CITY OF ALBUQUERQUE

Site: El Vado/Casa Grande

Re: Drainage Ordinance (14-5-2-1) Violations for Erosion and Sediment Control

SCHEET NO.
ESC 104

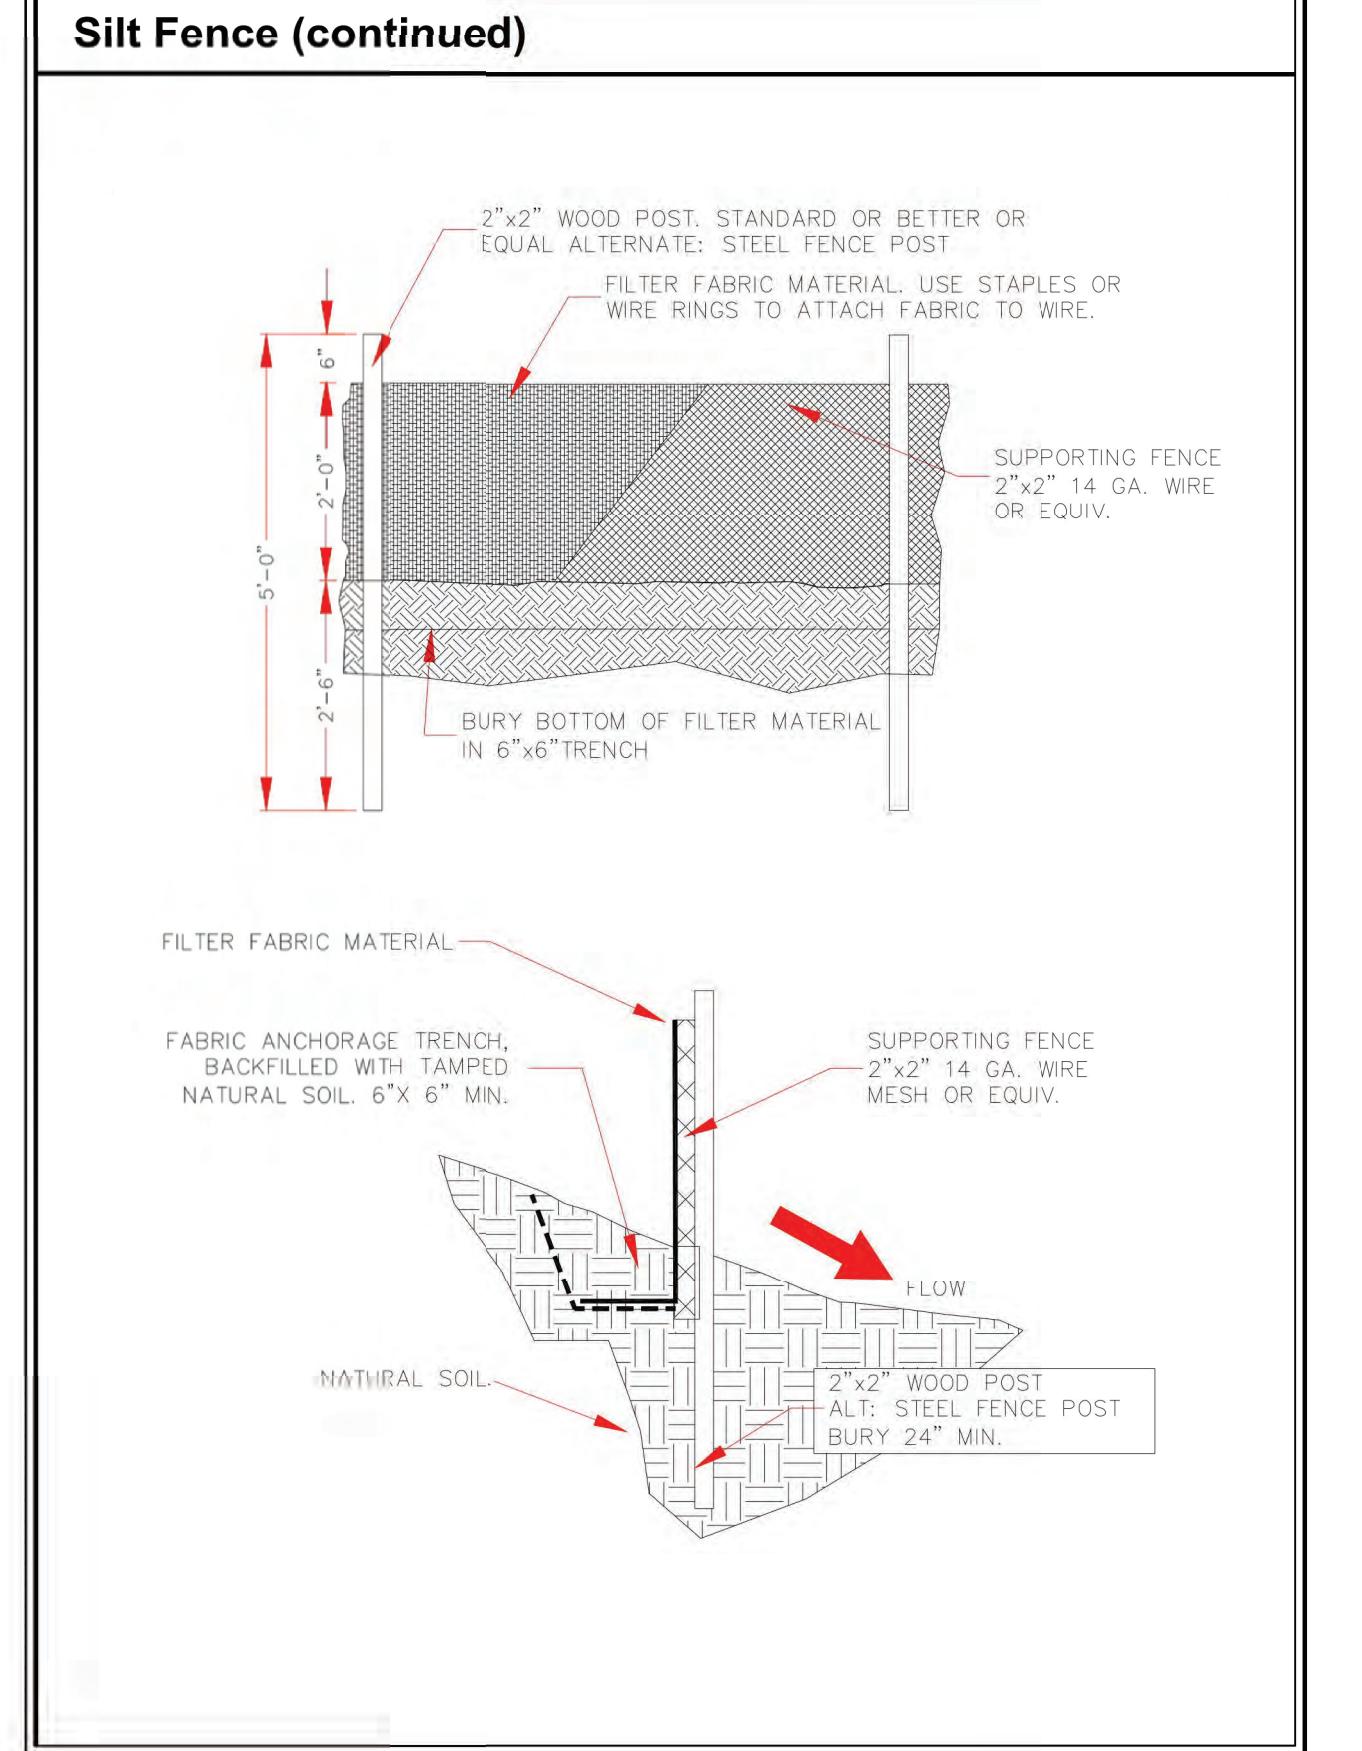
1. The stabilized construction exit/track-out pad is in poor condition.
2. There was sediment in Central Ave.

1. Install a stabilized construction exit/track-out pad per the approved Erosion and Sediment Control plan.
2. Remove the sediment from the street and gutter in Central Ave. along the project frontage.
